PEDESTRIAN WIND ENVIRONMENT STATEMENT

16-20 MIDDLE HARBOUR ROAD, LINDFIELD

WJ864-01F02(REV1)- WS REPORT

PTI ARCHITECTURE (SYDNEY) PTY LTD

1 LEVEL 9  
1:250

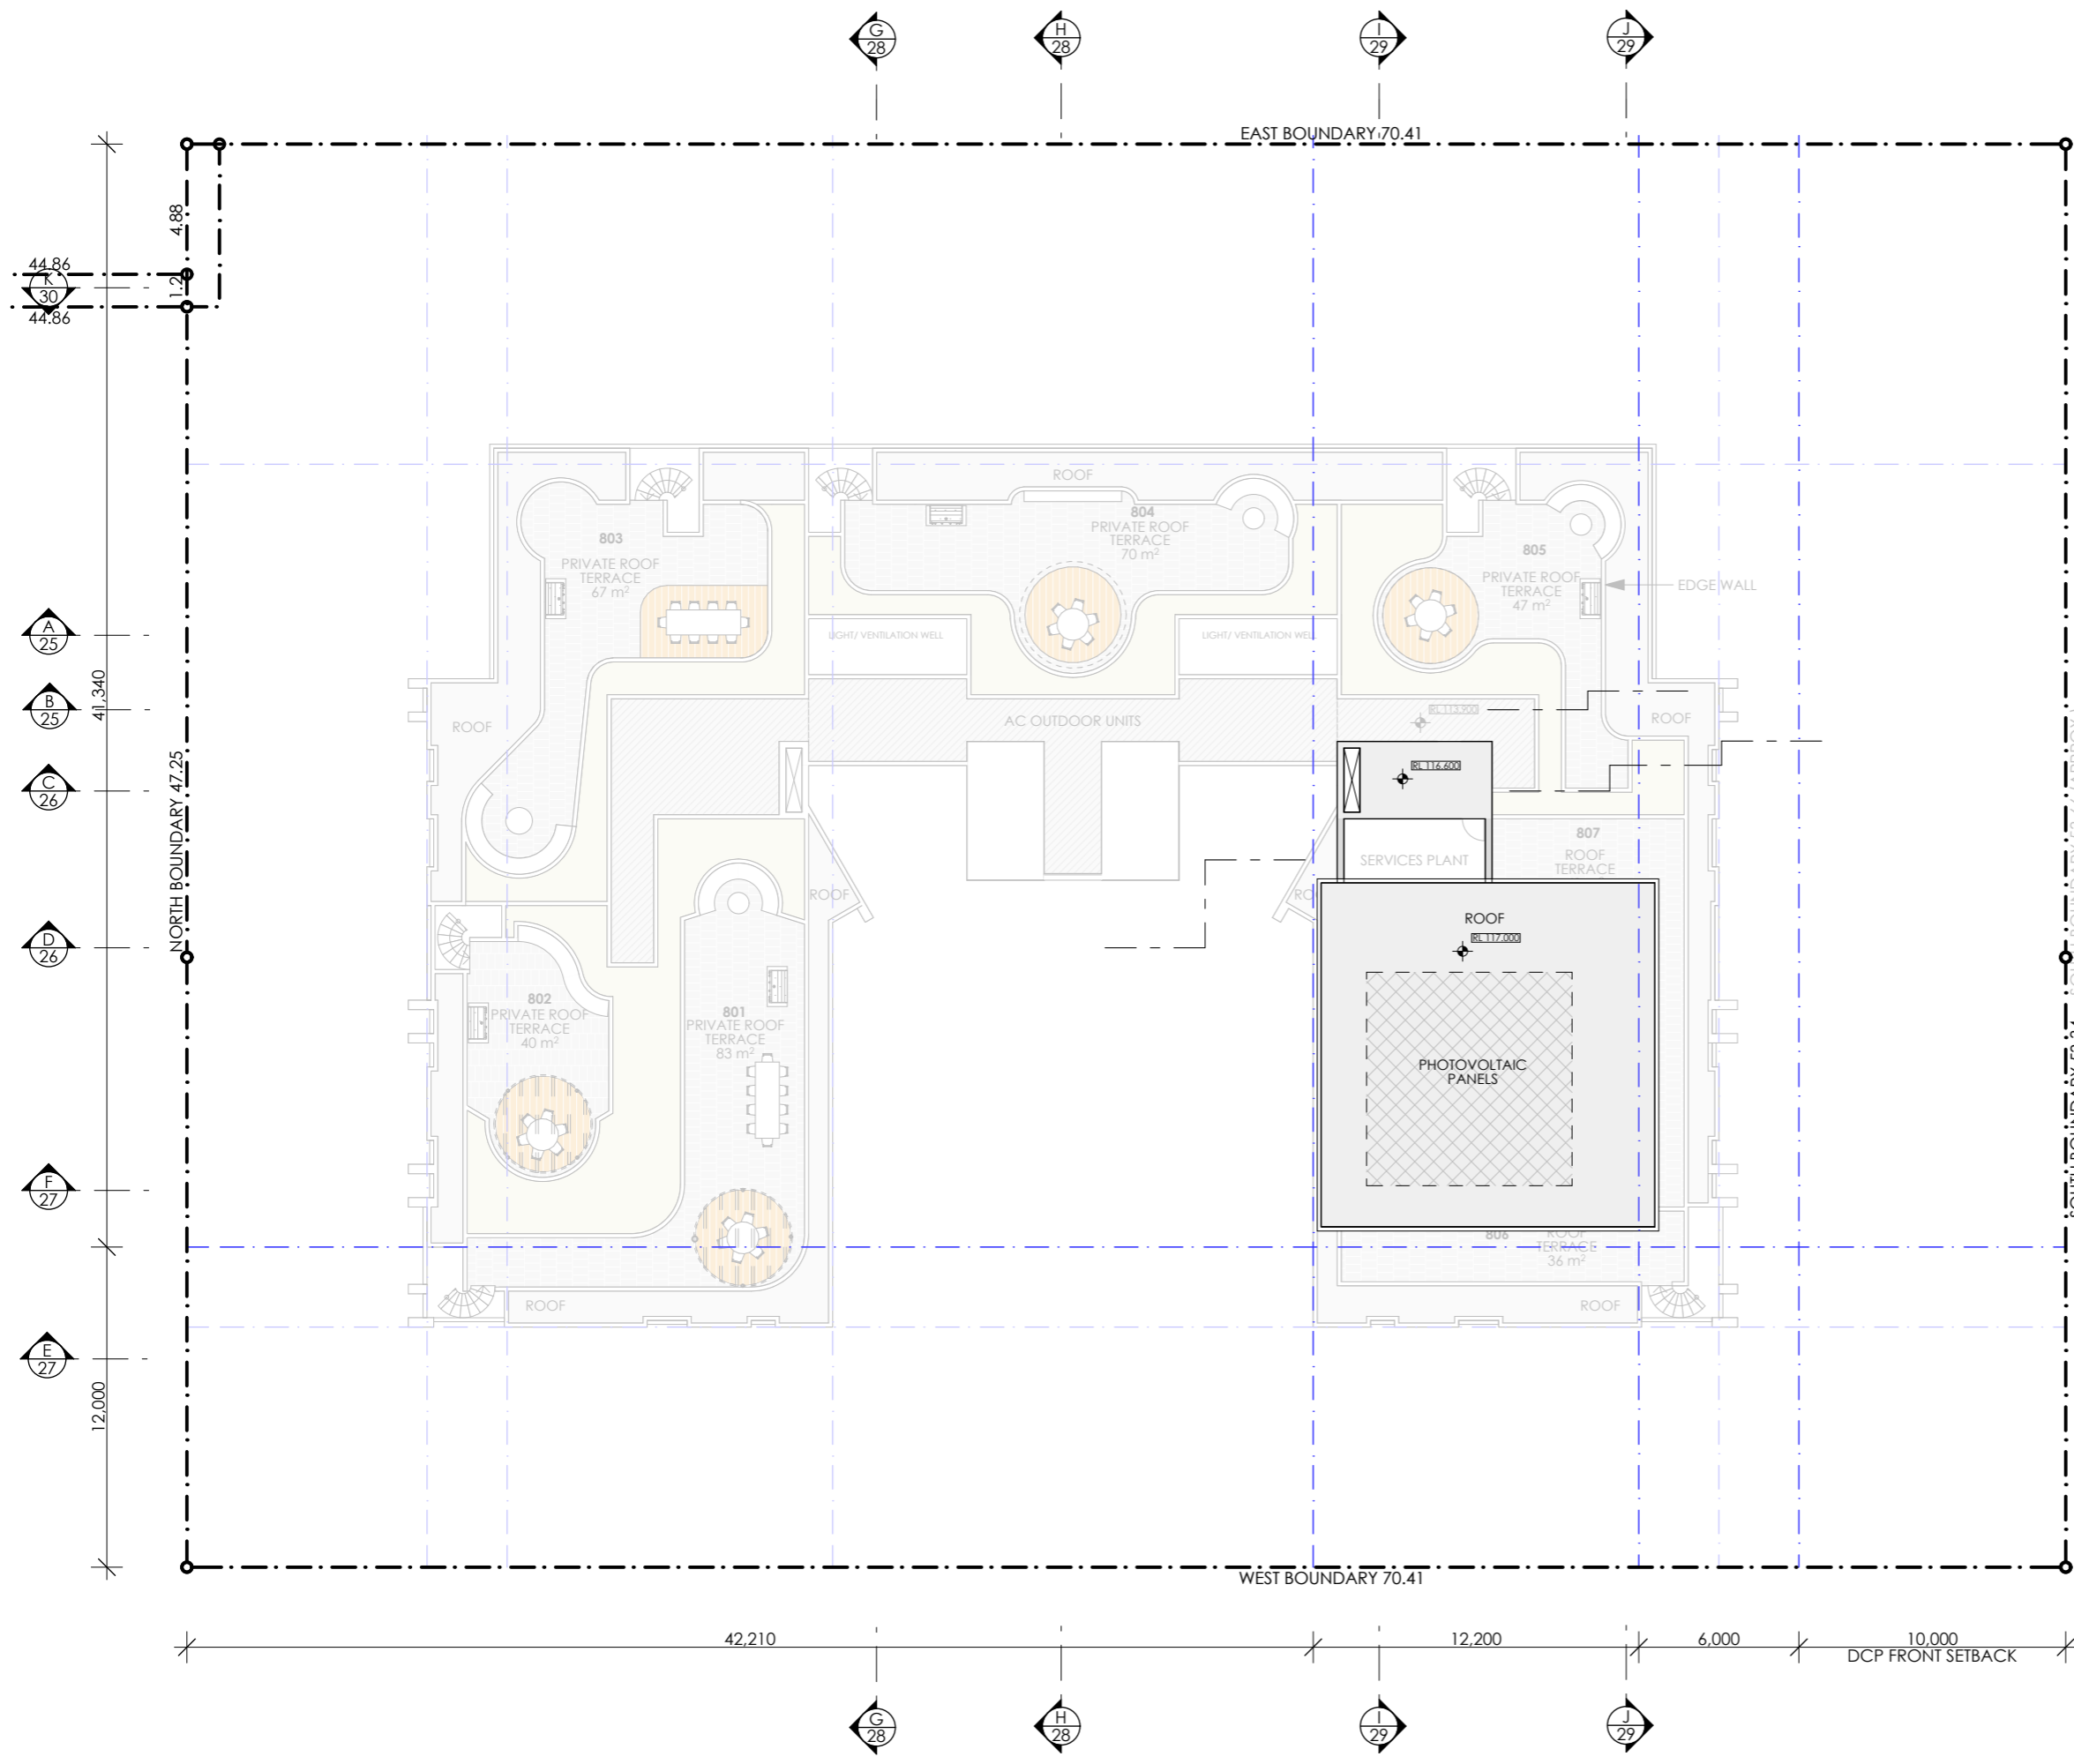
The development features roof-top terrace spaces at Level 9. Given the height of the subject development in relation to the surrounding building morphology, the roof-top areas are generally exposed to the prevailing winds from all the directions. This can generate direct, side-streaming and/or corner acceleration effects (latter off the split-level penthouse enclosure) that can affect the patrons.

- Increasing the height of the proposed balustrades around the edges of the all the individual terraces to 1.5m.
